About the application

Application number: 2020/94184	
What is the application for?:	Erection of car port (Within a Conservation Area)
Address of the site or building:	Stonecroft, Daisy Lea Lane, Lindley, Huddersfield, HD3 3LL
Postcode:	HD3 3LL

Drawing Number: **846 03 SK-01**

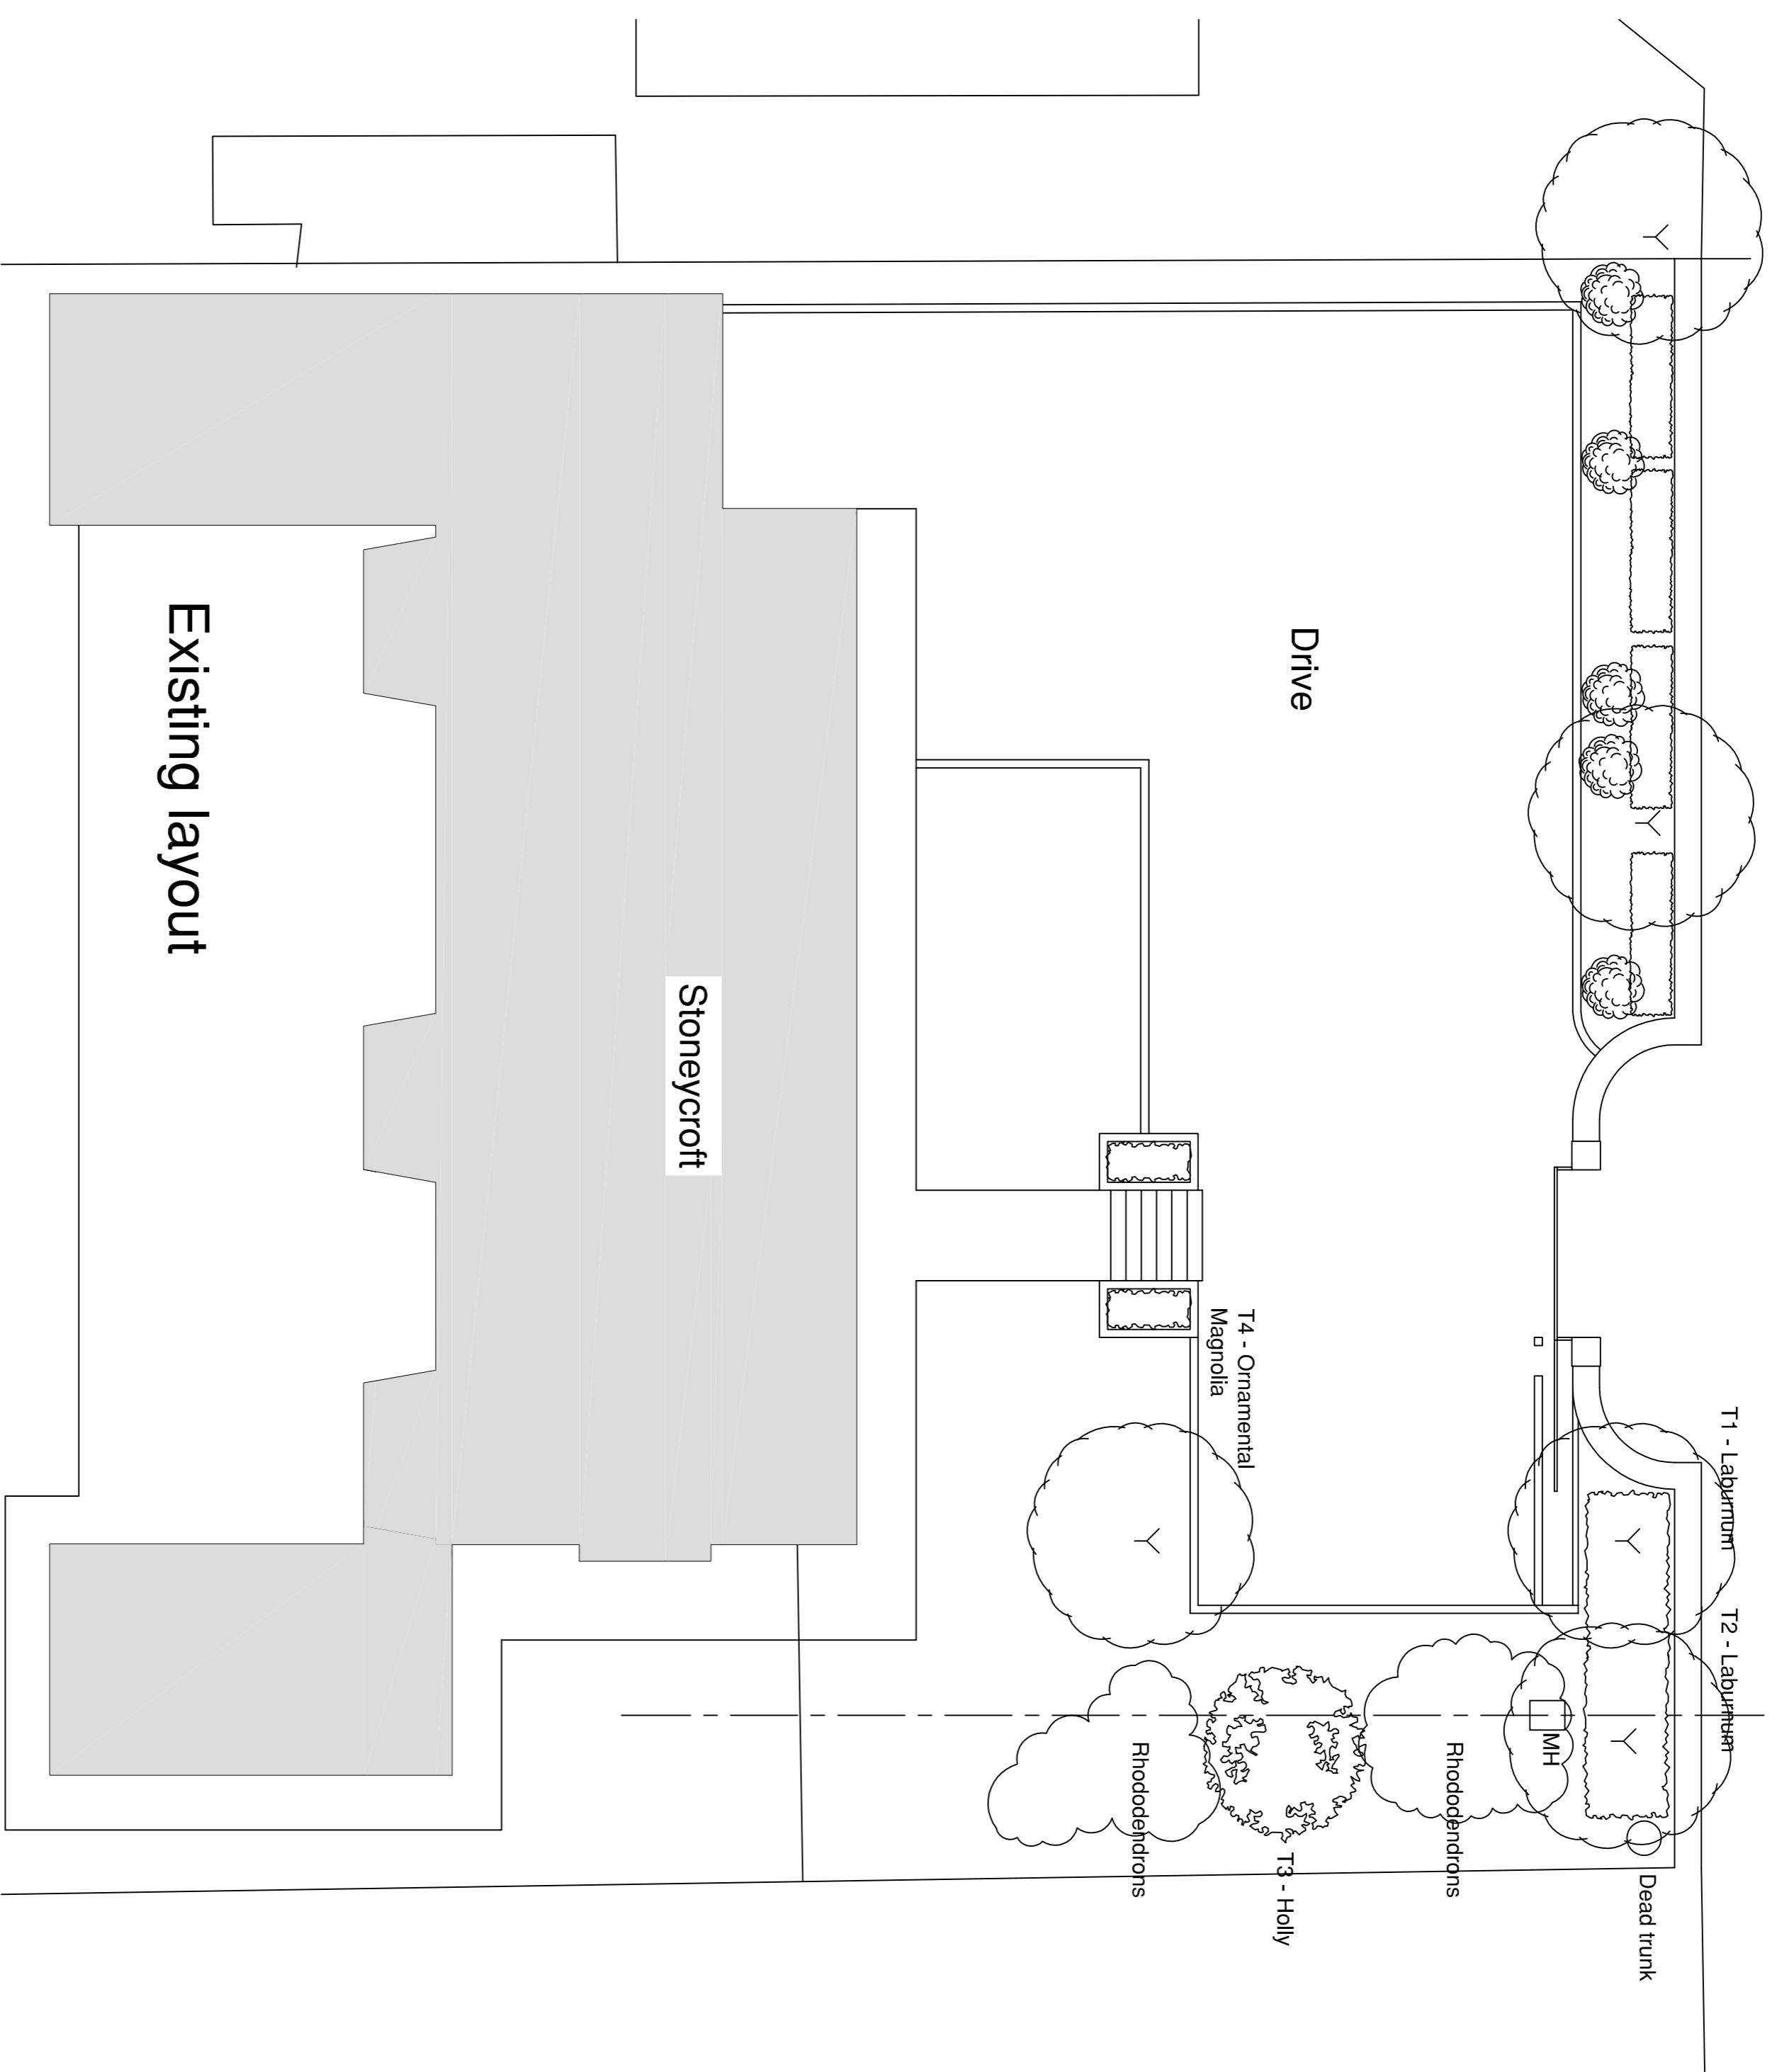
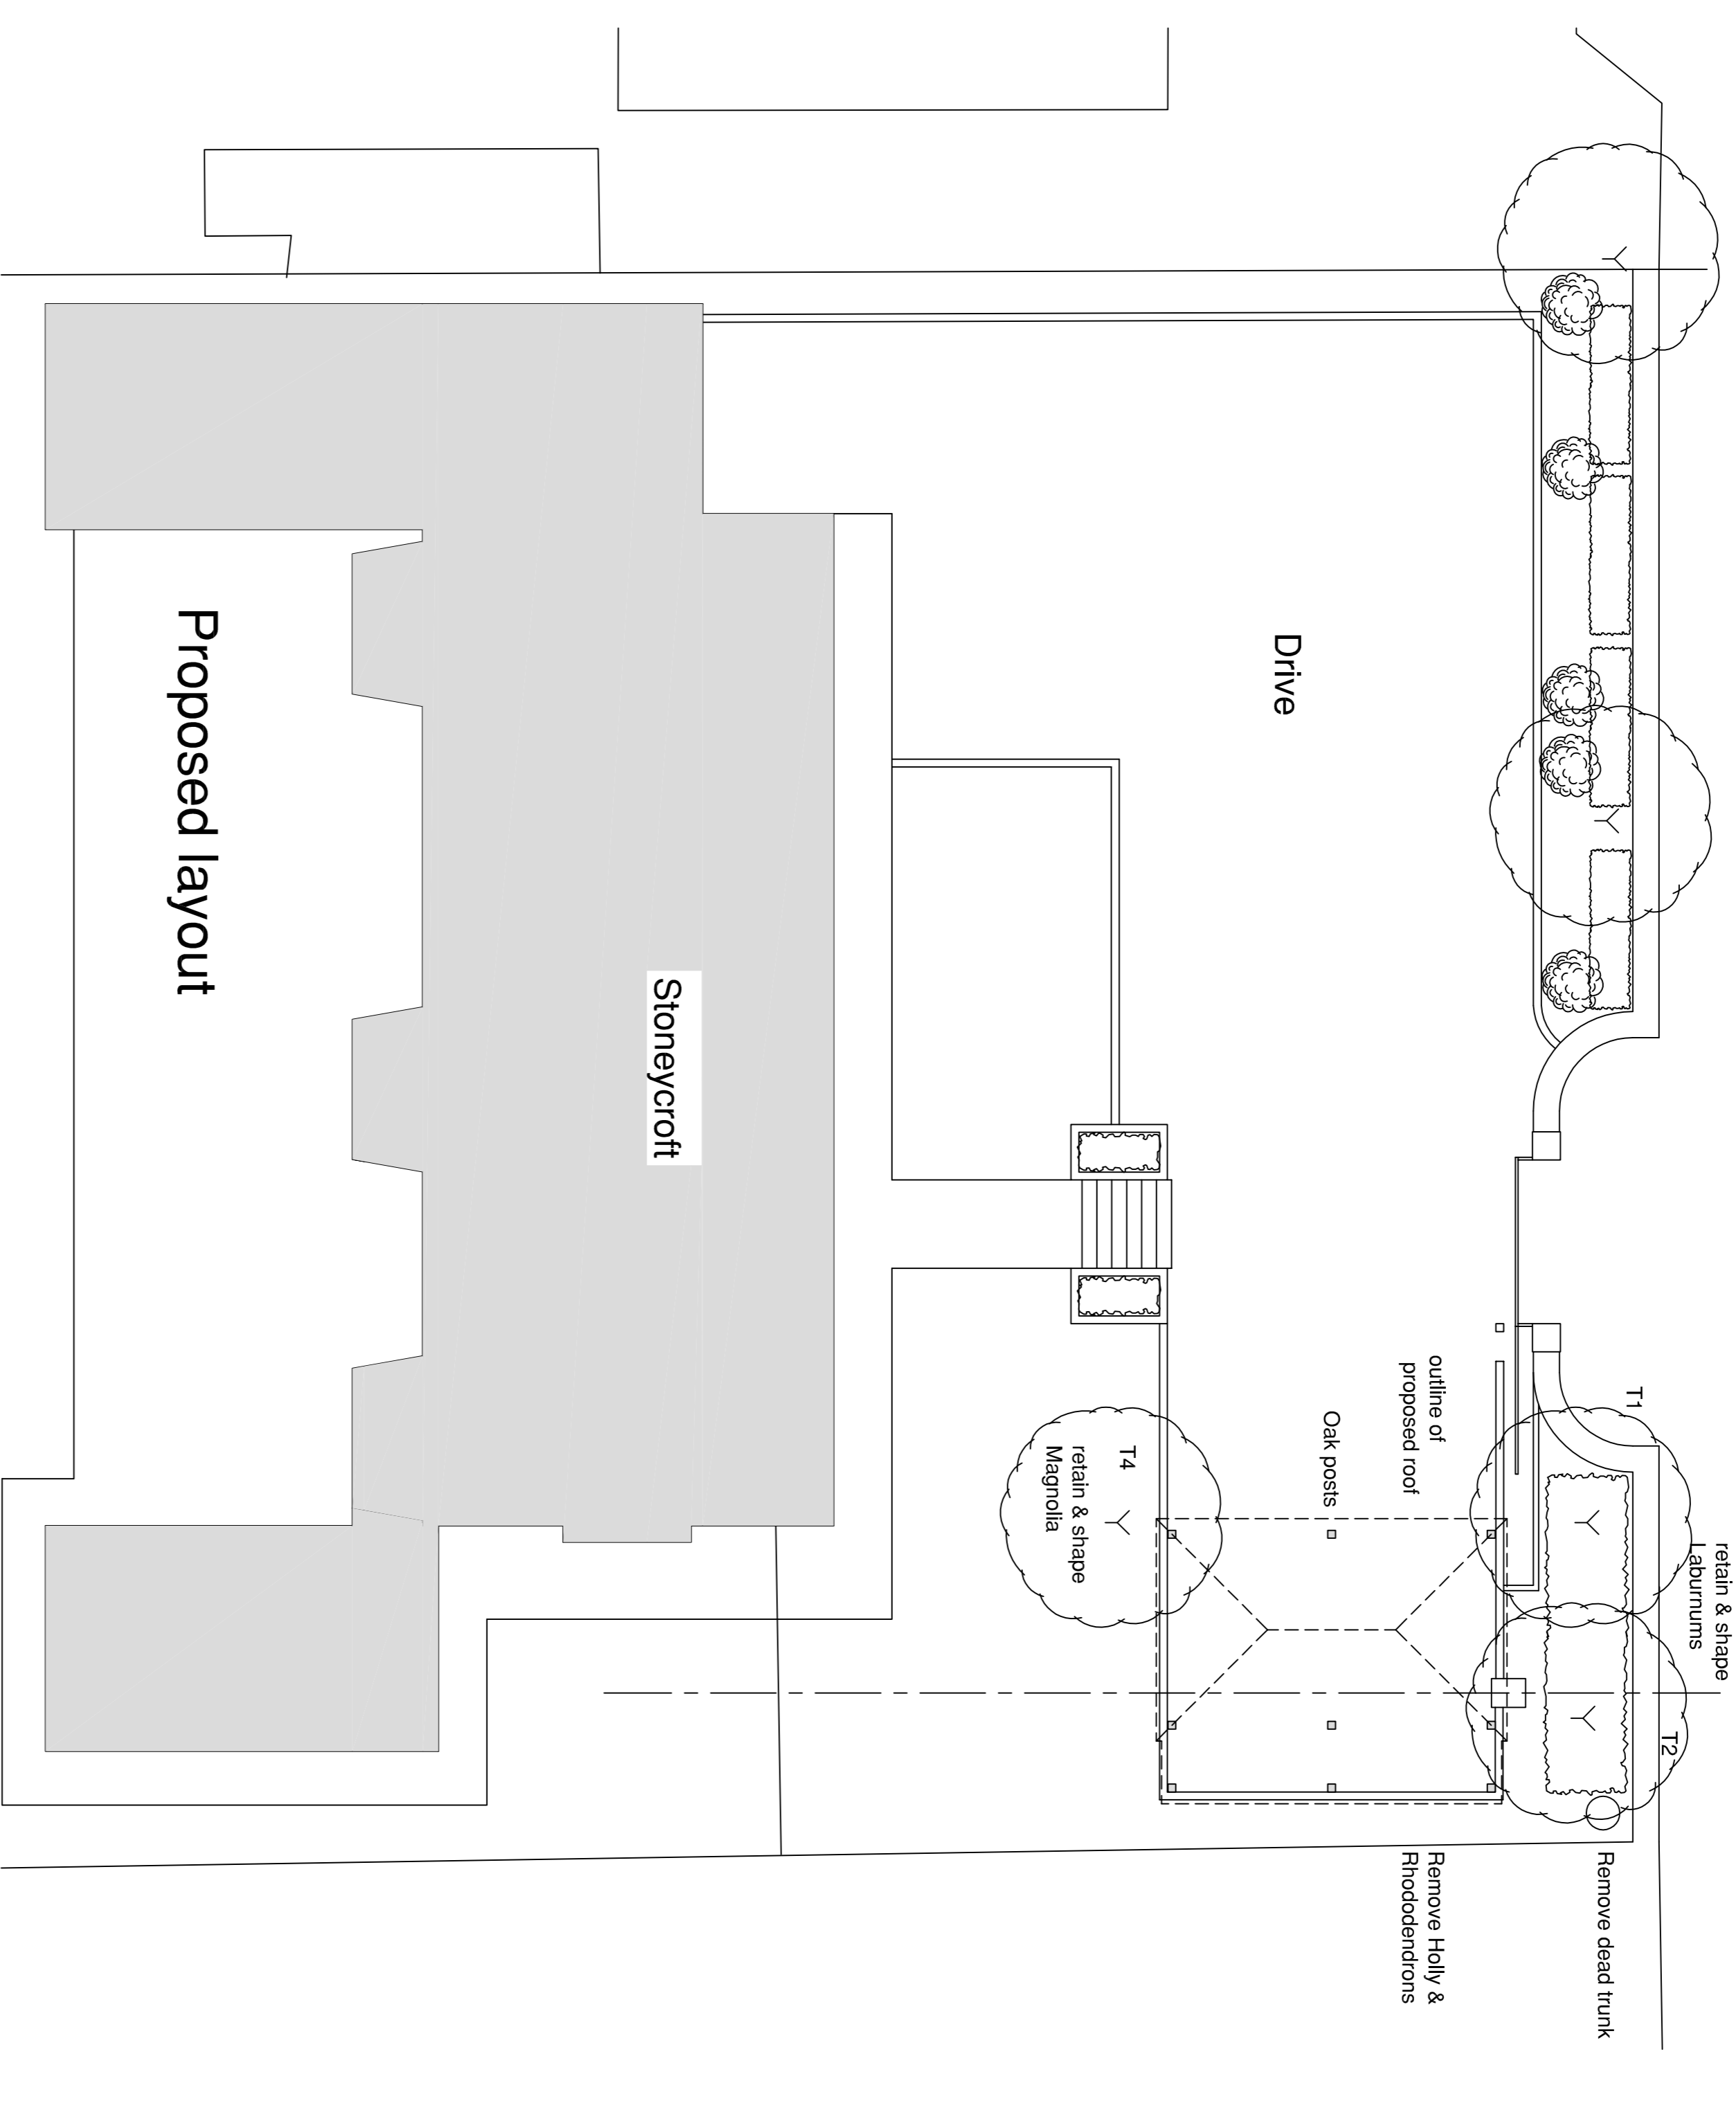
This proposal (application 2020/94184) is to add a new, free-standing car port 6.25m x 5.0m x 3.99m high filling much of one side of the space between house and road. The lower part of this structure would be see-through between oak posts, but the part between 2.1m and 3.99m above ground would be tiled roofing. To accommodate this structure it is intended to remove large rhododendrons and a holly along the side boundary of this property, remove substantial branches from two full-size laburnum trees close to the Daisy Lea Lane boundary and remove a major part of an attractive large, mature magnolia closer to the house. There is no mention of foundations being required, how close they would be to the road or side boundary or the potential for damage to the roots of the laburnums and magnolia. A recent application for a similar, slightly larger, car port with tiled roof in a nearby road described a need for foundations at least 1m deep.

I believe that the applicant's drawings omit specific information on a number of important matters including: distance from the proposed structure to the privet hedge and wall along Daisy Lea Lane, the actual surface area of green canopy to be removed and the need for, plus impact of, foundations.

- 1) This new free-standing building would constitute 'infilling' within the Edgerton Conservation Area;
- 2) It would be the first structure to be built in front of the building line on this section of road in the Edgerton Conservation Area and therefore spoil this line which has been maintained over many decades;

- 3) The prominent location, very close to Daisy Lea Lane as it rises away from Halifax Road, means it would be clearly visible along all of Daisy Lea Lane from the bottom at Halifax Road to the barrier across a much higher section of the road;
